DECISION DELEGATED TO HEAD OF PLANNING

Application No: H07-0986-22 **Applicant:** Mrs R Zdroba

Proposal: Erection of two storey dwelling - retrospective - approved under H07-0815-20. Modification of Condition 1 to allow amendments to previously approved plans

Location: 32 Hillgate Gedney Hill Spalding

Proposed Elevations

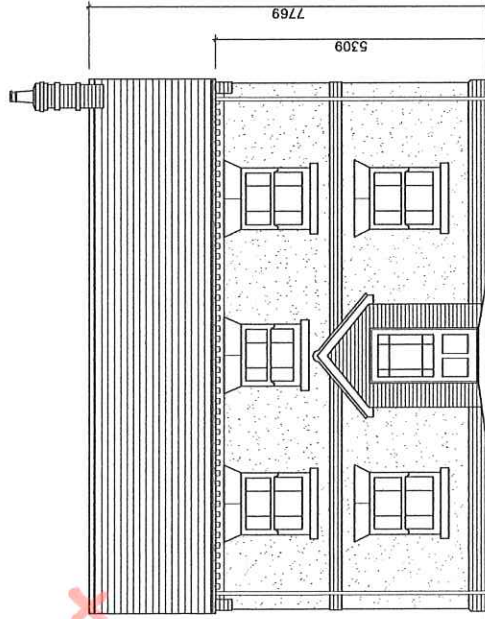
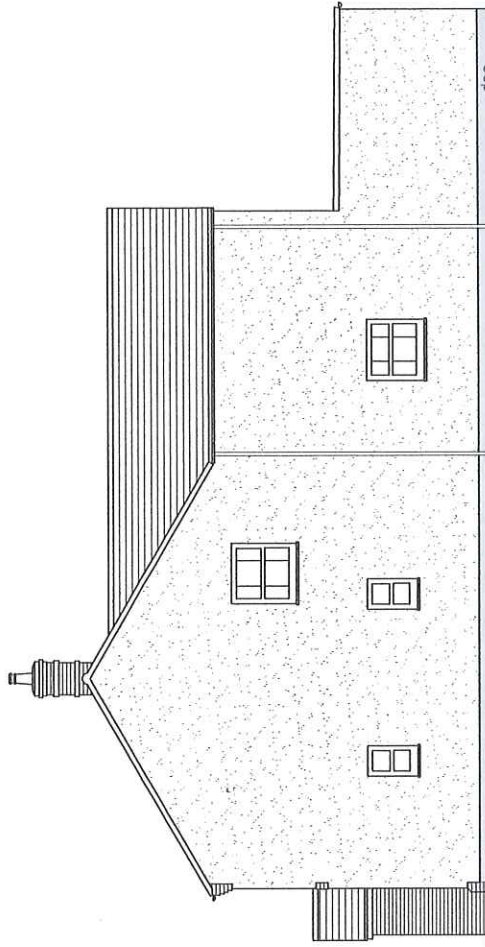
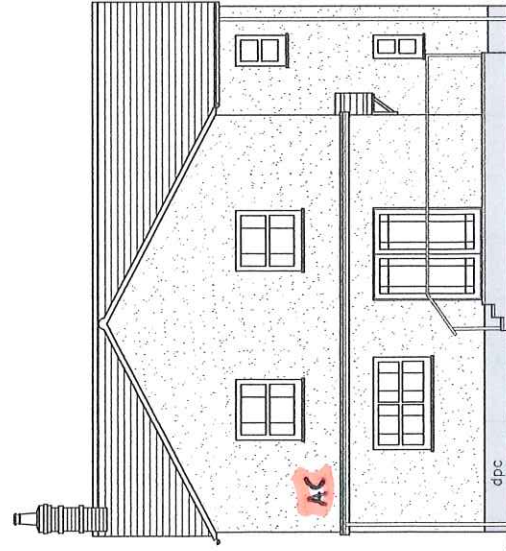
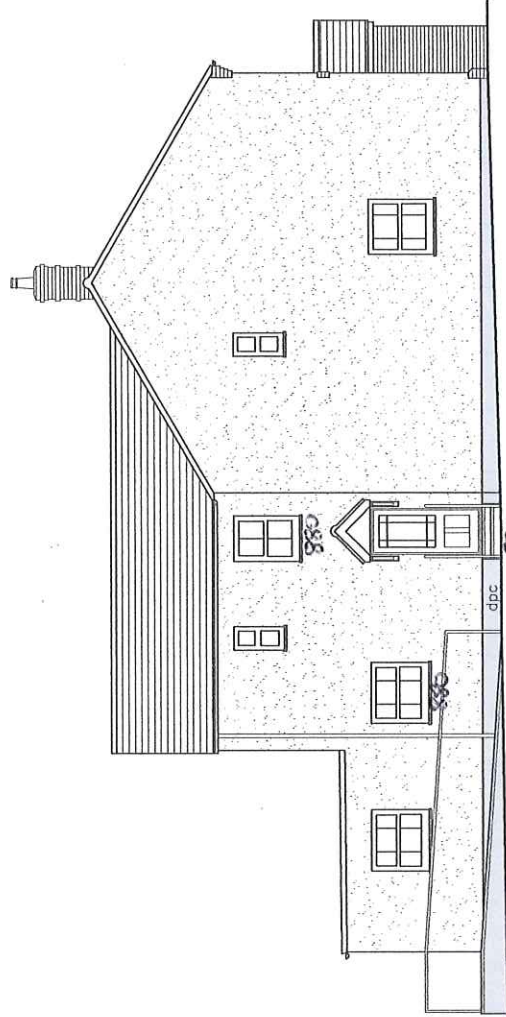
The current application proposes an AC unit on the rear elevation of the previously approved dwelling and to exclude the left hand side chimney previously approved.

A local resident has objected to the proposal on grounds that the removal of the second chimney will alter the street scene significantly. The concerns are noted, however, properties in the immediate vicinity vary in appearance and it is not considered that removal of one of the chimneys unacceptably alters the overall appearance of the dwelling or the street scene.

With regards to the AC unit, given its location to the rear of the site it is not considered to unacceptably impact on the street scene. In addition, given its modest size it appears as a minor addition to the existing rear elevation and does not appear overly prominent.

Concerns have been raised by a local resident with regards to noise from the new air conditioning unit. The concerns are noted, however, the closest dwelling is located approximately 15 metres from the air conditioning unit therefore it is not considered to result in any unacceptable impact on neighbouring amenity. In addition, given the unit only serves a single residential dwelling and by virtue of its modest size it is not considered that any unacceptable levels of noise would result from this.
